From: Jeff Watson
Sent: Wednesday, November 06, 2013 8:11 AM
To: Chuck Cruse (cruseandassoc@kvalley.com)
Subject: FW: BL-13-00027 Widner

[BL-13-00027 Widner](#)

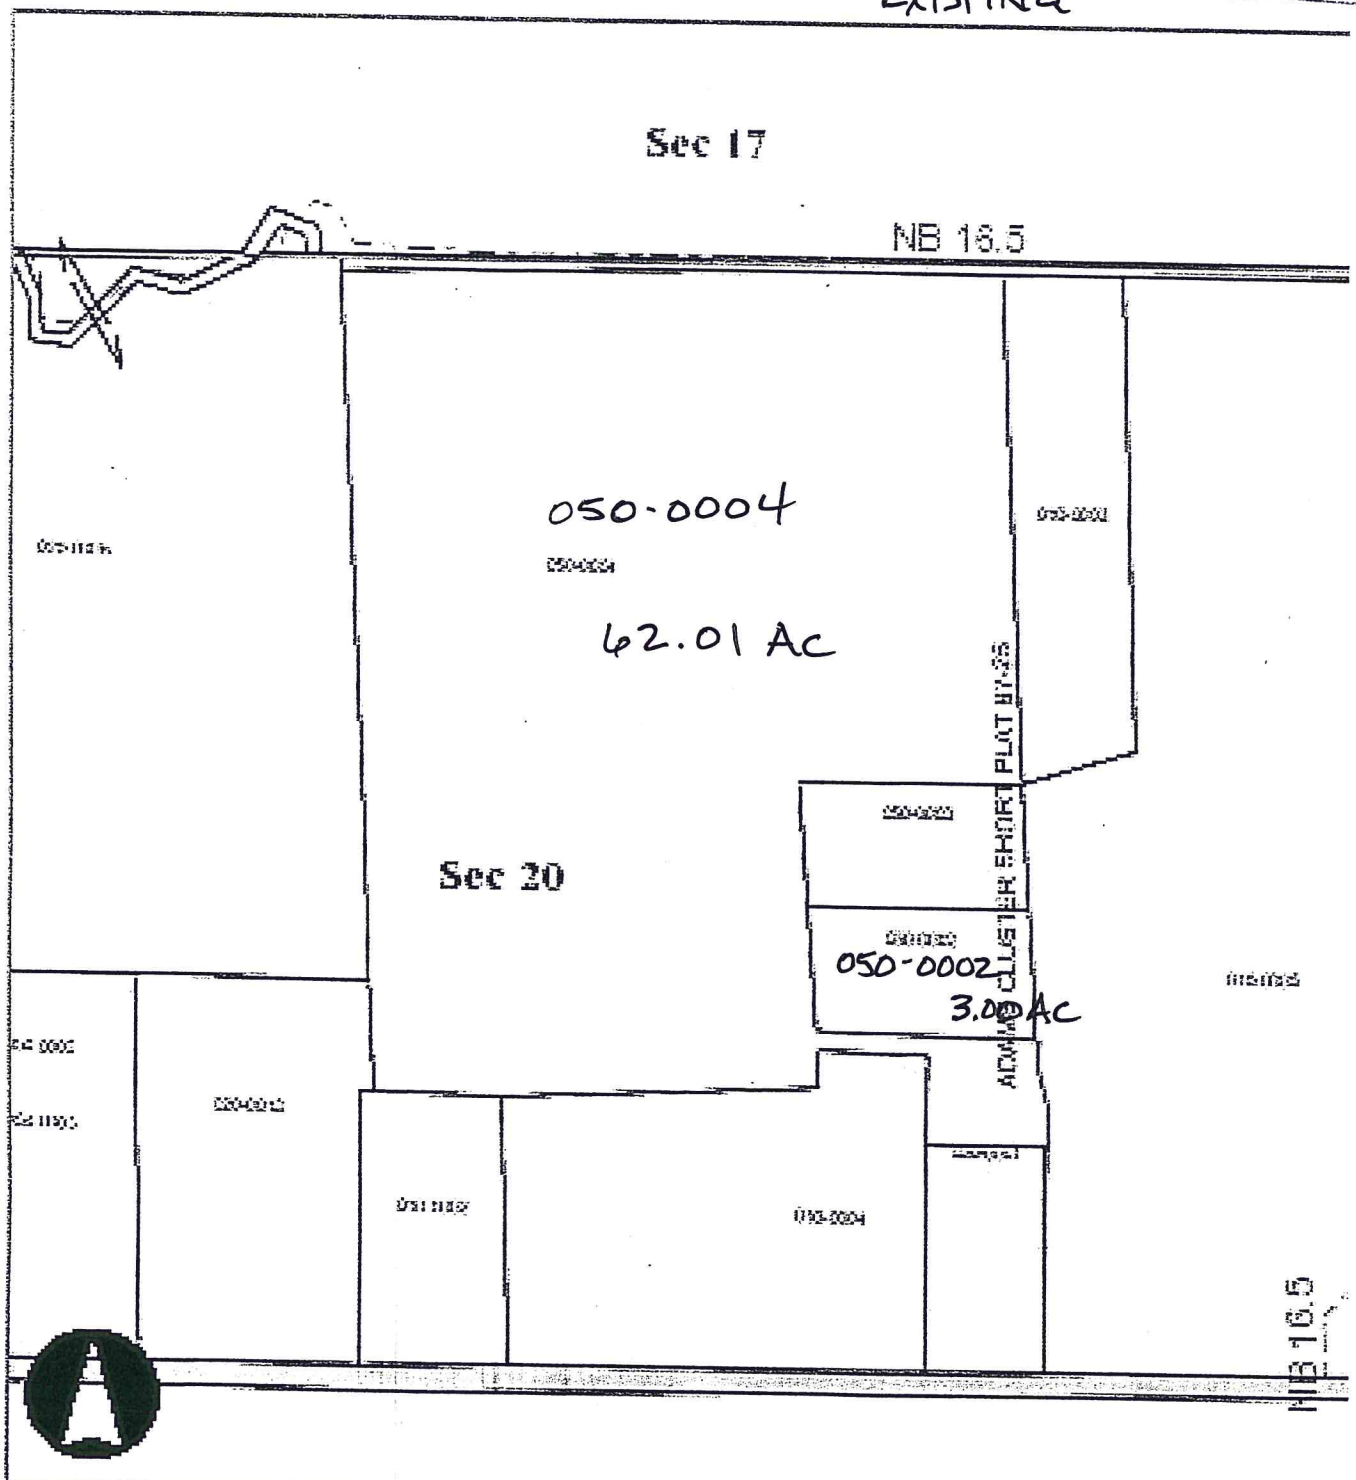
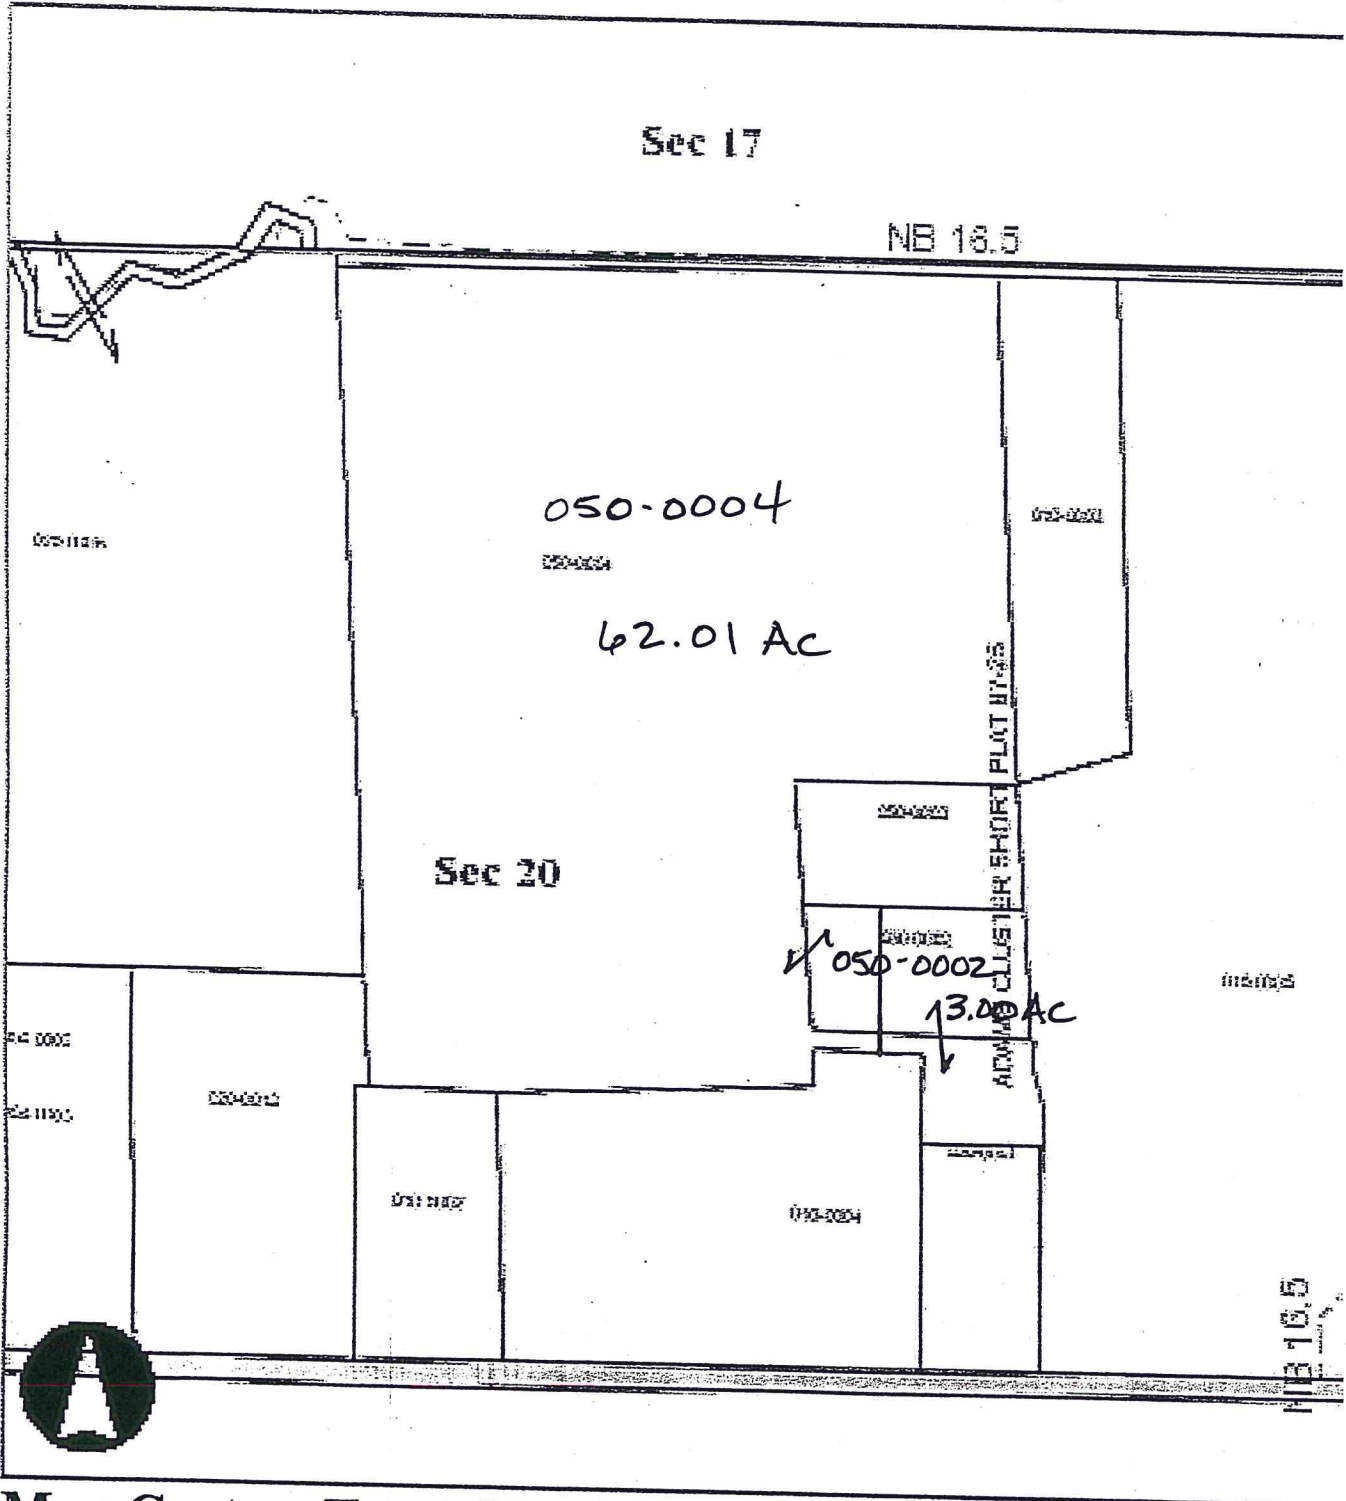
Public Health would like to see the existing well locations. Thank you.
